M60/M62/M66 Simister Island Interchange

TR010064

7.26 APPLICANT'S RESPONSES TO DEADLINE 4 SUBMISSIONS

APPLICANT'S RESPONSES TO DEADLINE 4 SUBMISSIONS

FIGURE 2.3

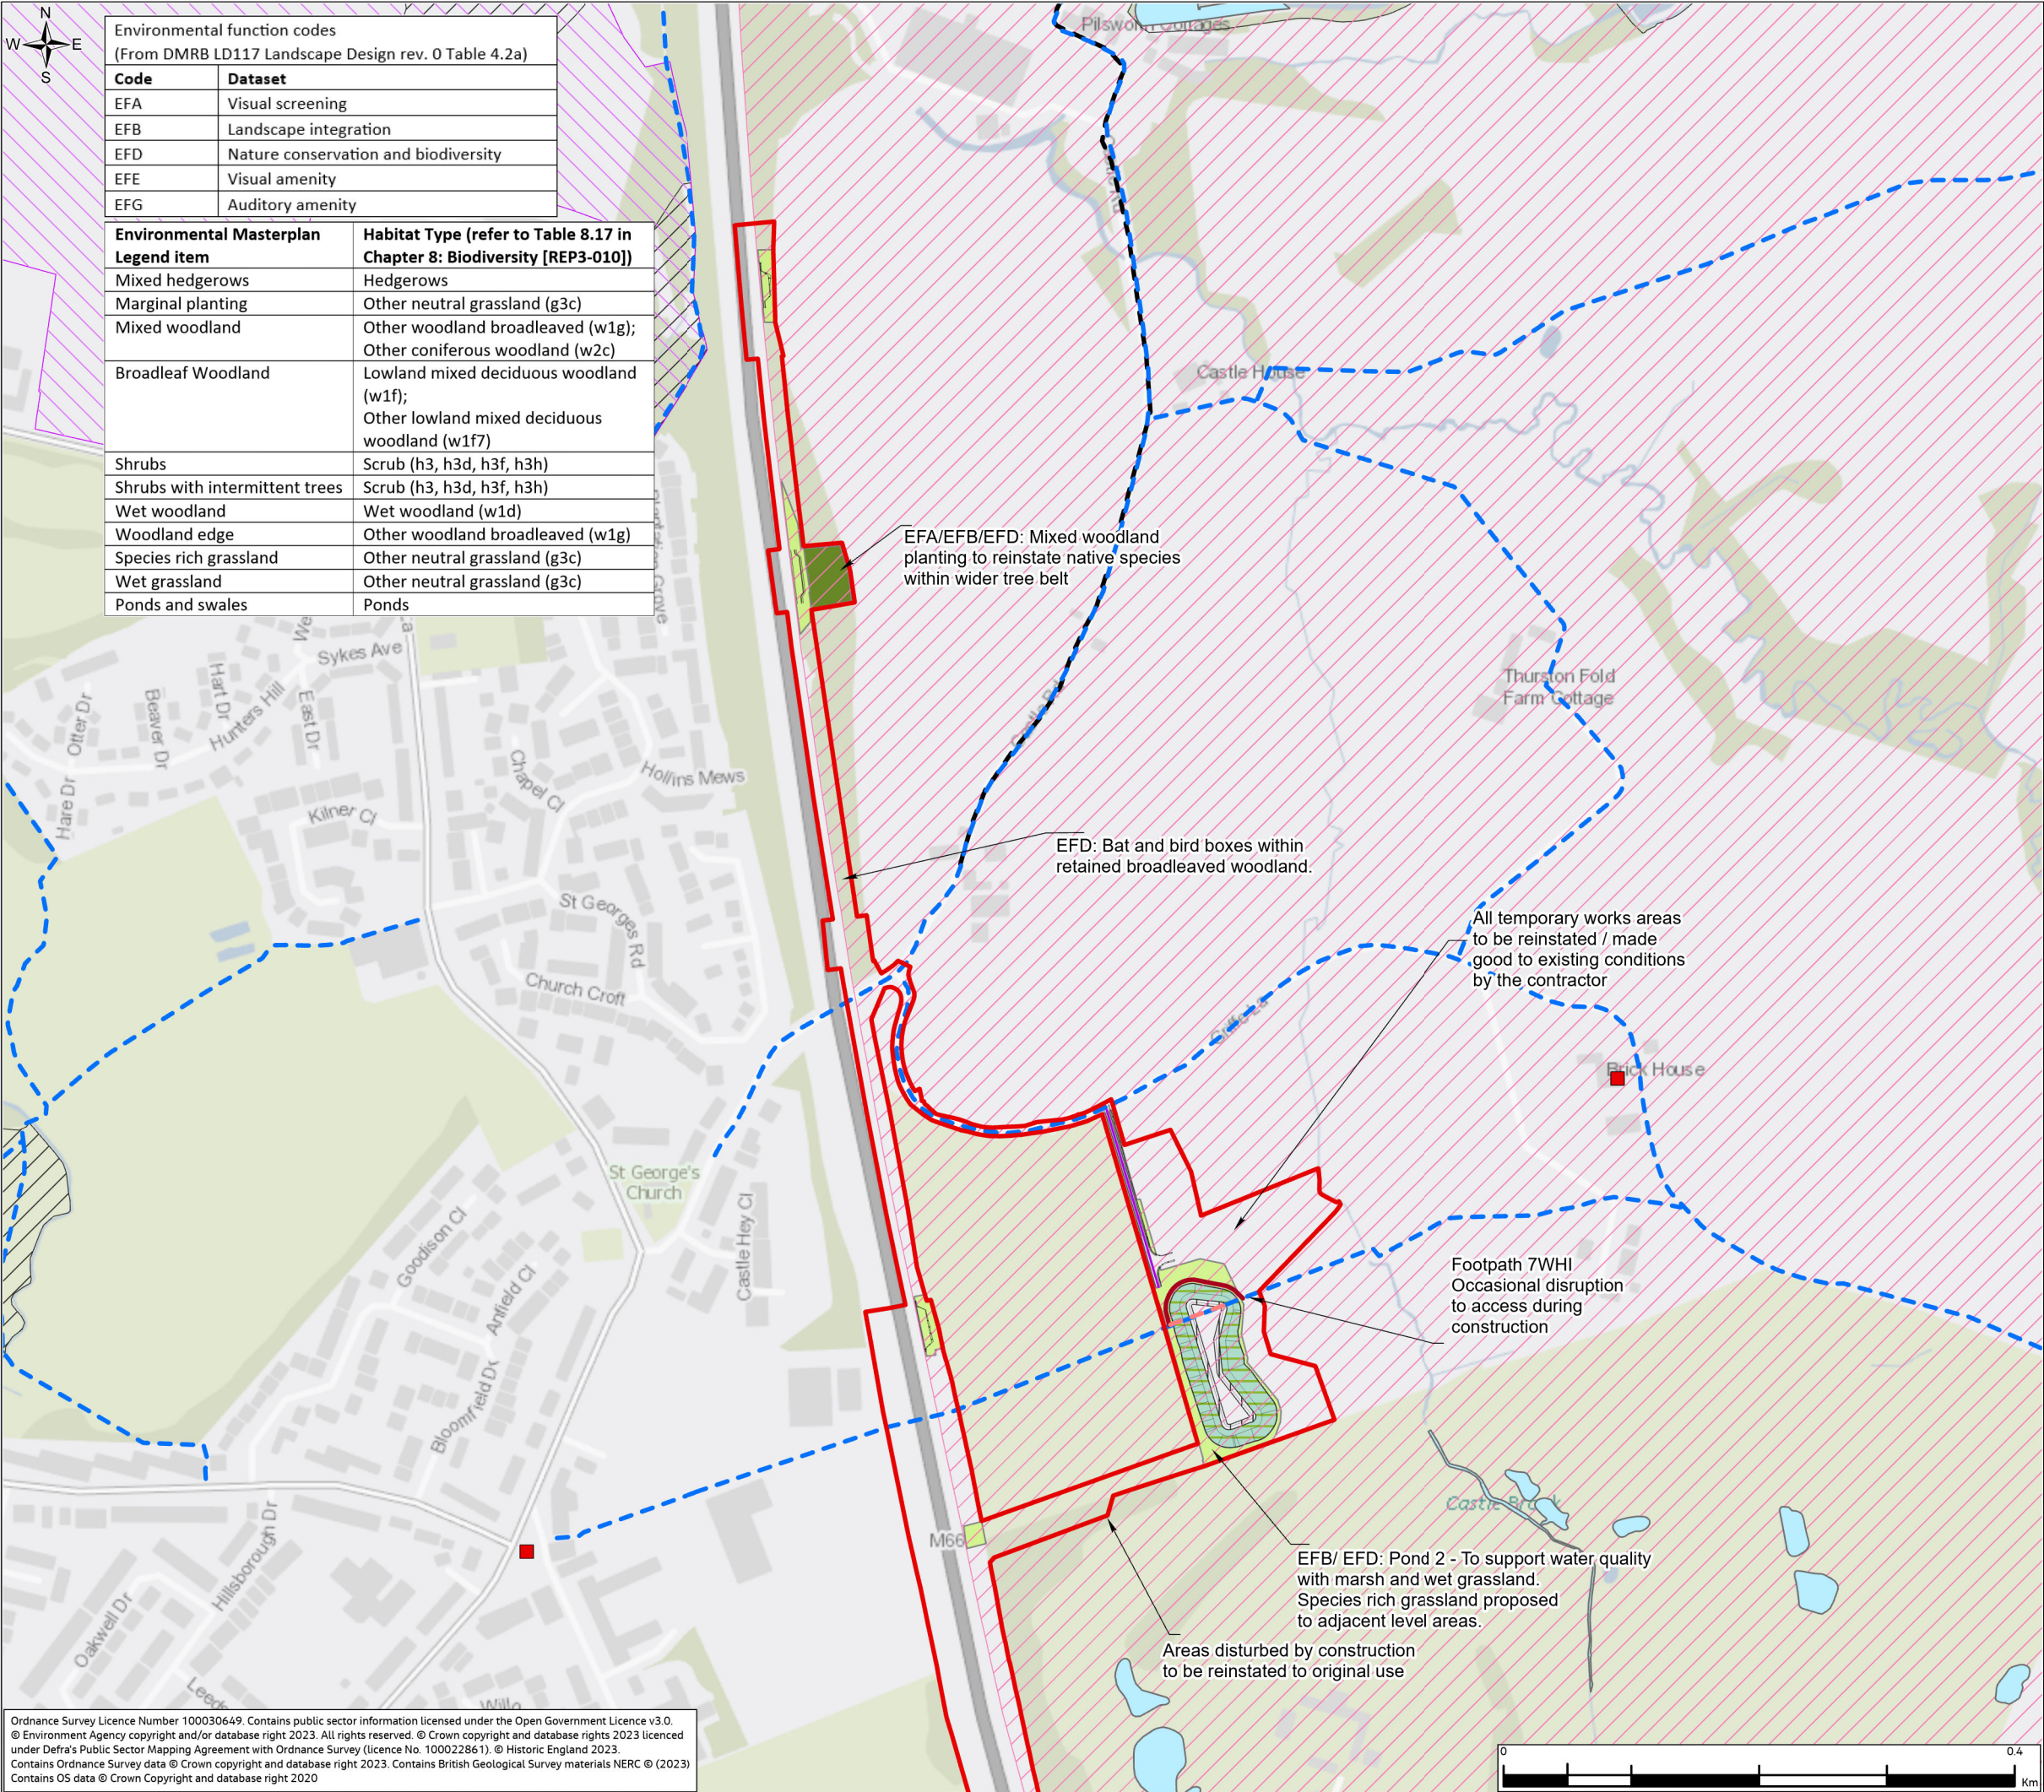
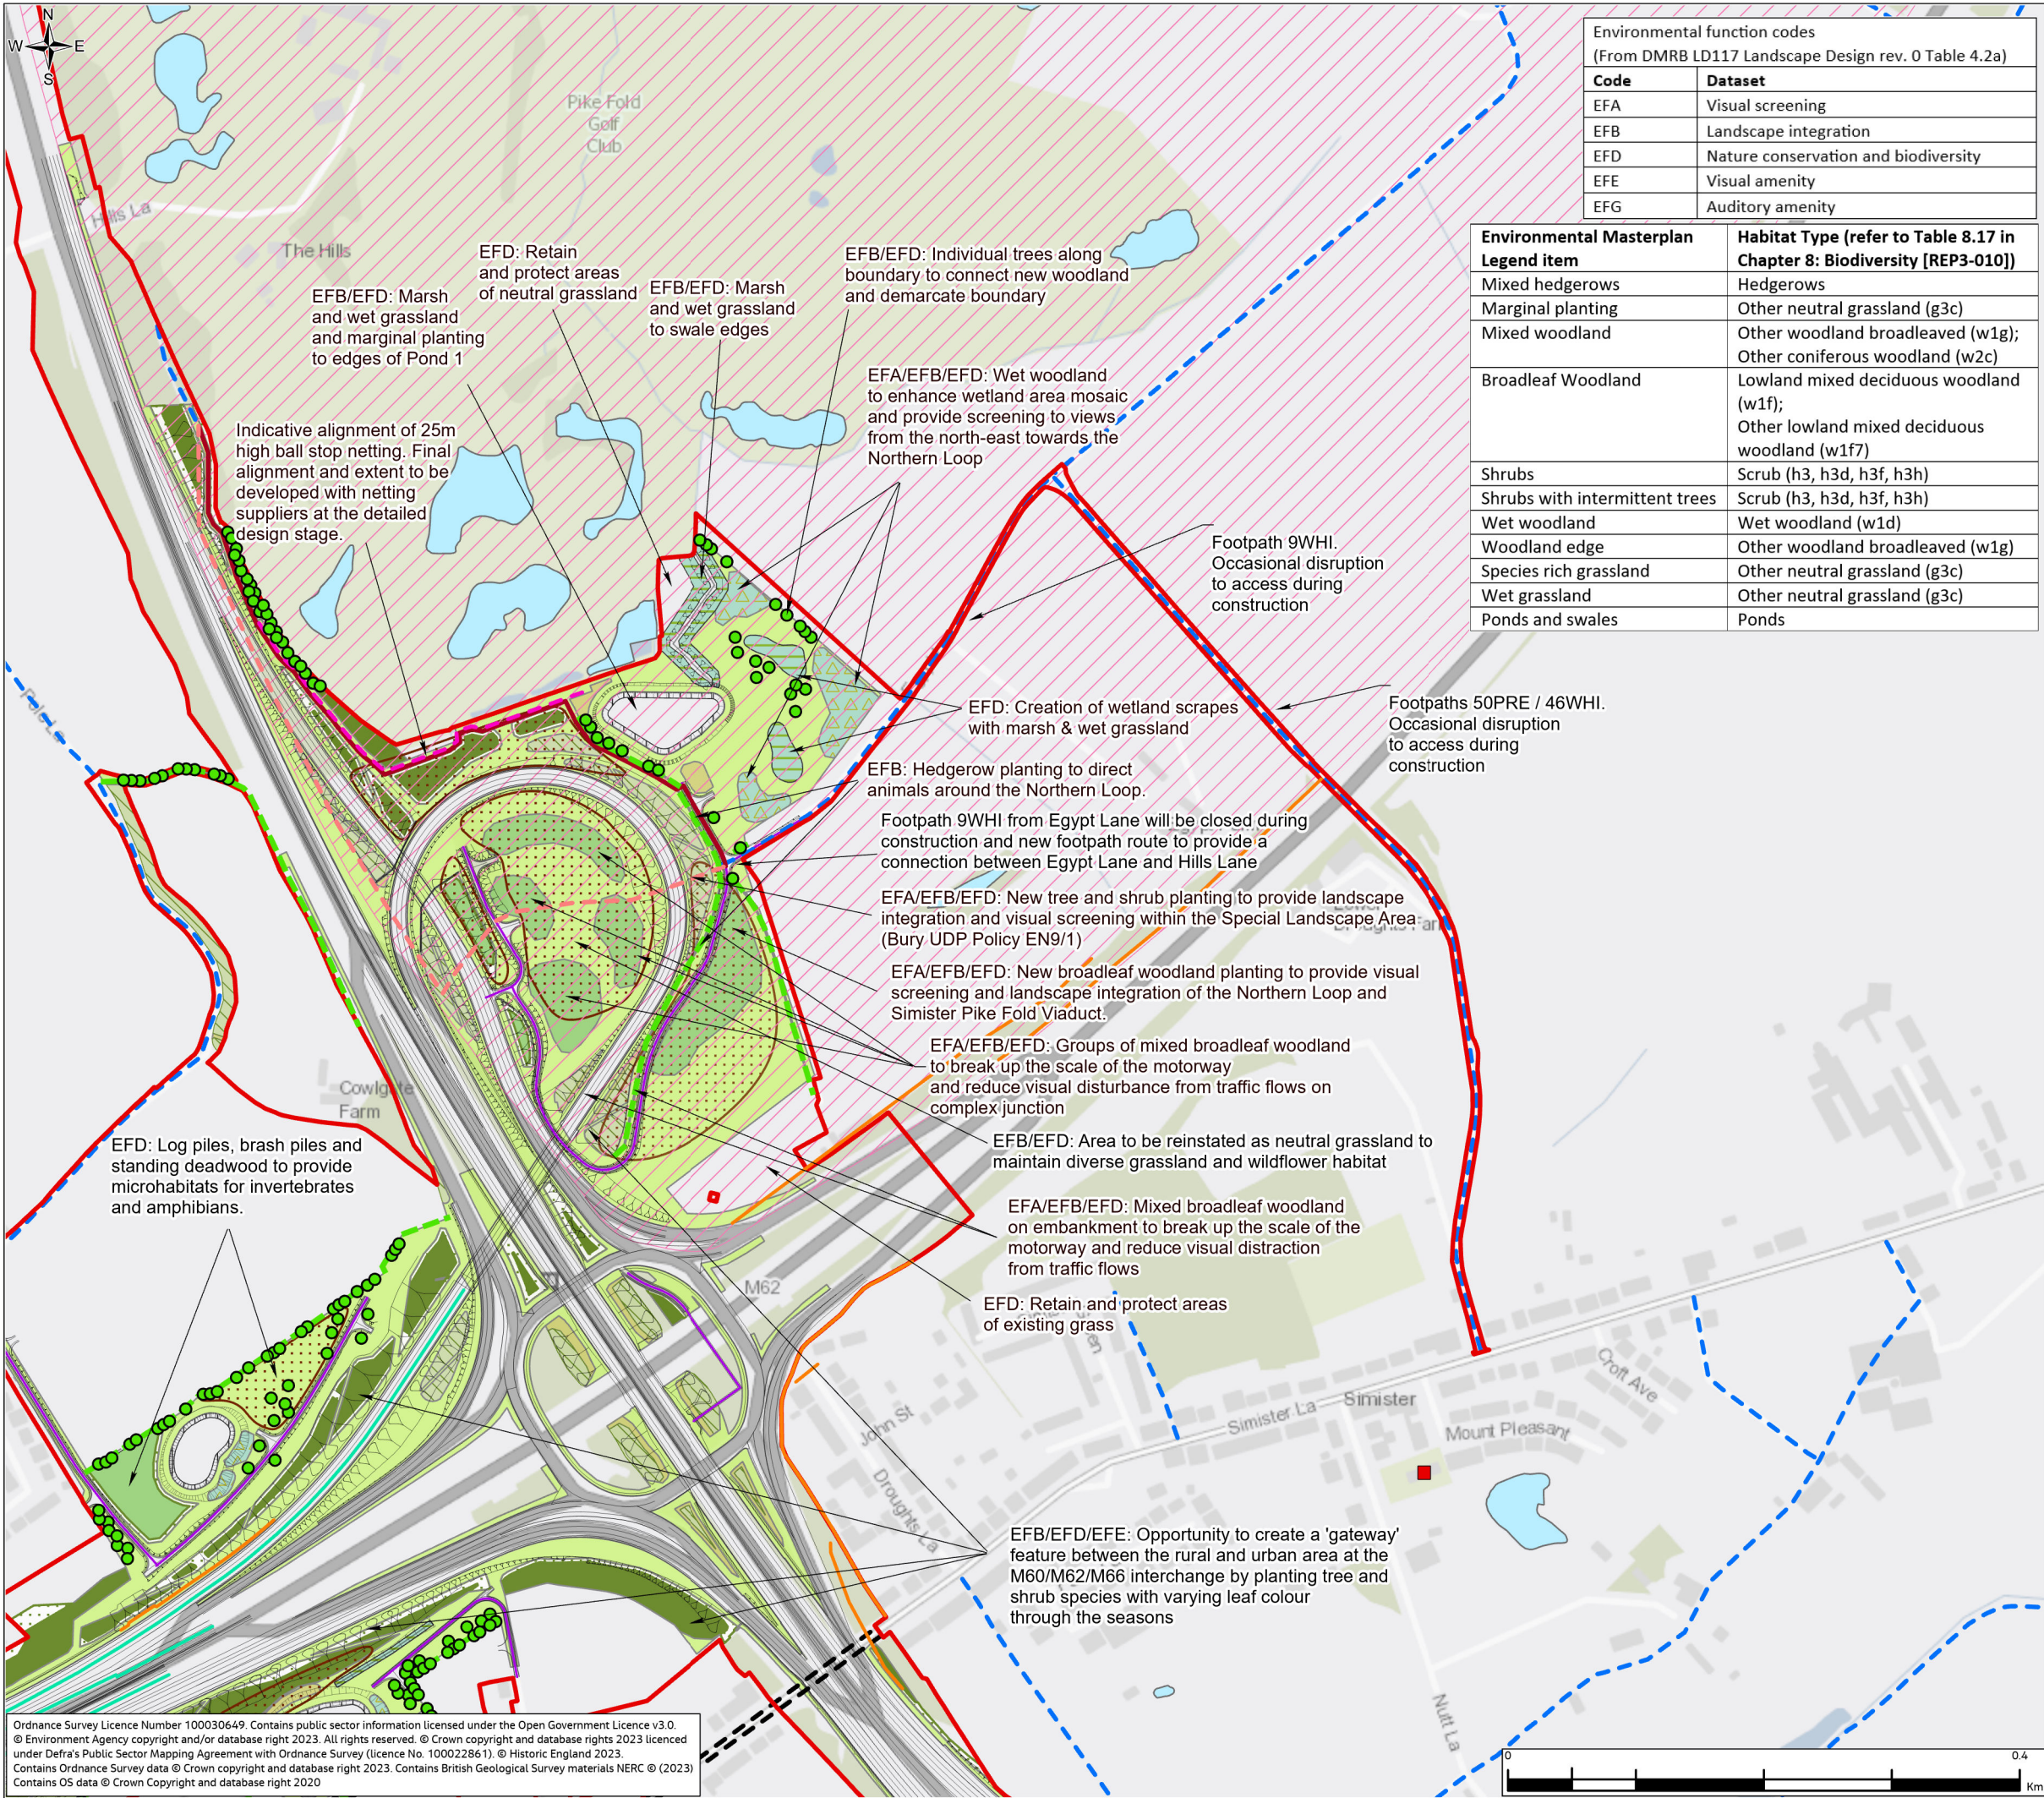
Reference	Hearing Action Reference / Other Reference	Action / Topic	Interested Parties Written Submission	Applicant's Response at Deadline 5
			<p>as mitigation proposals can be provided elsewhere. Figure 2.3 of the ES (Environmental Masterplan Sheet 2 of 5, APP-057) reveal indicative locations of tree planting, wet woodland, and log and brash piles. We submit that they do not require the Applicant to permanently acquire the entirety of both EMAs.</p> <p>1.10. Finally, the Applicant in its Response describes the acquisition of the EMAs as being "driven by the temporary works areas" and needed to "control and manage the remediation". This suggests that the EMAs are being acquired largely out of convenience, rather than any compelling need. The result is that the Hillary Family is taking on most of the burden of environmental mitigation despite a lack of evidence as to the need for that to be the case.</p>	<p>Please refer to the Applicant's response to ISH2 Action 30 [REP4-028] in relation to 1.8 of the Interested Party's written submission where the Applicant describes the requirements for visual screening during operation. The Applicant confirms that receptors at representative viewpoints VP3, VP5 and VP7 would experience moderate adverse (significant) effects due to views of the Northern Loop and Simister Pike Fold Bridge, and views of moving traffic on the elevated structures in the Scheme opening year. With mitigation planting on the Simister Pike Fold Bridge embankments and Northern Loop the effects would reduce to slight adverse (not significant) by year 15 as reported in Chapter 7 Landscape and Visual of the Environmental Statement [APP-046]. A slight adverse (not significant) effect has been assessed at VP4 during both operation year 1 and year 15.</p> <p>Please refer to the Applicant's response to ISH2 Action 30 [REP4-028] in relation to 1.9 of the Interested Party's written submission which details which essential mitigation is proposed within the environmental mitigation areas.</p> <p>Please refer to the Applicant's response to ISH2 Action 30 [REP4-028] in relation to 1.10 of the Interested Party's written submission which details which essential mitigation is proposed within the environmental mitigation areas. The ability to control and manage the remediation of land required for temporary works will enable the Applicant to ensure the optimum conditions for establishment of this mitigation planting and hence contribute to the likely success of the mitigation planting. In addition, by using these temporary works areas for essential environmental mitigation, the overall land take for the Scheme is reduced compared to siting environmental mitigation outside of these areas.</p>

<p>REP4-031g</p>	<p>Written Submission of Oral Case</p> <p>ISH2 Action 30 and ISH2 Action 31</p>	<p>Environmental Mitigation – Site Selection</p>	<p>2.2 The Hillary Family considers that the Application materials do not adequately justify the disproportionate burden of environmental mitigation proposed to be located in the north eastern 'quadrant' of the scheme. This is particularly evident in the lack of environmental mitigation in the NW and SW quadrants. Whilst small parcels of land are proposed for environmental mitigation purposes, there exists an opportunity to allocate additional land here for any required mitigation. The NW quadrant has been allocated for use as the site compound and materials storage area. This land is to be disturbed as a result and, whilst a small area has been allocated to accommodate an attenuation pond and an area of environmental mitigation and tree screening, a large area to the south of Mode Hill Lane (approx. 15.5 acres) remains available for further environmental mitigation on land not allocated for alternative development. The Hillary Family contends that this area, being contiguous to and easily accessible from an existing residential area could be provided for environmental mitigation and could also serve as an area of public amenity for local residents. A greater area than is currently allocated in the SW quadrant could also be utilised for environmental mitigation both to the west and east of Corday Lane. This totals approximately 8 acres on land not allocated for alternative development.</p> <p>2.3. In summary the Hillary Family considers believe the proposed</p>	<p>The Applicant's response to ISH2 Action 30 [REP4-028] explains that some of the environmental mitigation is site-specific and needs to be delivered within the north-east quadrant to be effective, including mitigation for bats, for integration of attenuation pond 1, to mitigate impacts to the Landscape Character Area, to mitigate visual impacts to residents, walkers on footpaths and visitors to Pike Fold Golf Course (VP3, VP5 and VP7), and to integrate the Northern Loop into the landscape.</p> <p>The Applicant's response [REP4-028] also explains that, by siting areas of non-site-specific habitat creation, to ensure no overall loss of biodiversity, in and around mitigation for specific receptors/impacts (bats, drainage, visual impacts), the Applicant maximises the value of these habitats as it is an established ecological principle (Making Space for Nature, Lawton 2010) that habitats which are bigger are more valuable compared to multiple smaller fragments of an equivalent total size.</p> <p>For the reasons outlined above, the Applicant considers that the design presented on Figure 2.3 Environmental Masterplan of the Environmental Statement Figures [APP-057] is the optimum solution for environmental mitigation.</p>

Reference	Hearing Action Reference / Other Reference	Action / Topic	Interested Parties Written Submission	Applicant's Response at Deadline 5
			location of the environmental mitigation areas on the Hillary Land to be inequitable, and (per the submissions at CAH1) that a compelling case to acquire the full extent of the Plots has not been made out.	
REP4-031h	Written Submission of Oral Case ISH2 Action 30 and ISH2 Action 31	Impact on Bats	<p>2.4 Further to the Hillary Family's submissions at CAH1, the Hillary Family note that the Applicant proposes to disturb a significant amount of potential bat roosting and foraging habitat in the clearance of the land in the NE quadrant of the scheme both on land required to construct the Northern Loop but also in clearing land required for temporary site compounds and soil storage, an area of approximately 27 acres.</p> <p>2.5. As above, Chapter 8 (Biodiversity) of the ES confirms (at 8.10.100) that no bat roosts exist within the Order limits and that should roosts be found during construction they will be mitigated by use of bat boxes. The Applicant concludes that the effect on roosting habitat is neutral. At 8.10.106 the Applicant confirms that whilst foraging habitat is lost, it would be small in relation to the overall amount of habitat available in the surrounding area. At 8.10.108 they confirm that the integrity of bat resource is not considered likely to be affected due to the mobility of bats and the availability of alternative foraging habitat in the wider landscape. The Applicant confirm that the effect on foraging habitat is neutral. In regard to habitat fragmentation the Applicant express some concern (at 8.10.109 - 8.10.111 inclusive) that commuting routes in the NE quadrant will be lost by virtue of the loss of just two hedgerows which they intend to replace with new hedgerow planting, though they acknowledge that the new vegetation would take time to mature. They anticipate that construction will take 2-3 years and it would be reasonable to assume that the hedgerows will take 3-5 years to mature, and so bat habitat will be affected for 5-7 years, during which there will be no bat resource other than that found in the wider landscape. The Hillary Family's considers that it would be reasonable to assume that the bat population, being mobile, will seek and find alternative habitat. As and when they do return, all vegetation around the northern loop will have matured and provide suitable roosting, foraging and commuting locations. At 8.10.114 and 8.10.115 the Applicant confirms that the bat species observed are light-tolerant species that can forage in a wide variety of habitats and that light spill would not impact foraging or commuting bats.</p>	<p>The Applicant refers to its response to ISH2 Action 30 [REP4-028] and to its response to ExQ2 BIO.2.1 provided at Deadline 5 of the Examination in relation to 2.4 of the Interested Parties written submission.</p> <p>Page 5 of 7 of Figure 8.3.1 within Appendix 8.3 Bat Survey Report [APP-091] shows the distribution of trees with bat roost potential within the north-west quadrant. A single tree with low bat roost potential (BT2) is located along Egypt Lane.</p> <p>Paragraph 8.10.105 of Chapter 8 Biodiversity of the Environmental Statement [REP3-010] summarises the loss of foraging habitat across the entire Order Limits, a total area of 31.13ha (and 0.88km of hedgerow). Of this, 9.97ha of bat foraging habitat and 378m of hedgerow are located within the land owned by the Hillary family.</p> <p>The assessment presented in paragraph 8.10.100 to 8.10.116 of Chapter 8 Biodiversity of the Environmental Statement [REP3-010] is an assessment of residual impacts, i.e. impacts from the Scheme with the implementation of mitigation which includes the provision of habitats in accordance with Figure 2.3 Environmental Masterplan of the Environmental Statement Figures [APP-057].</p>
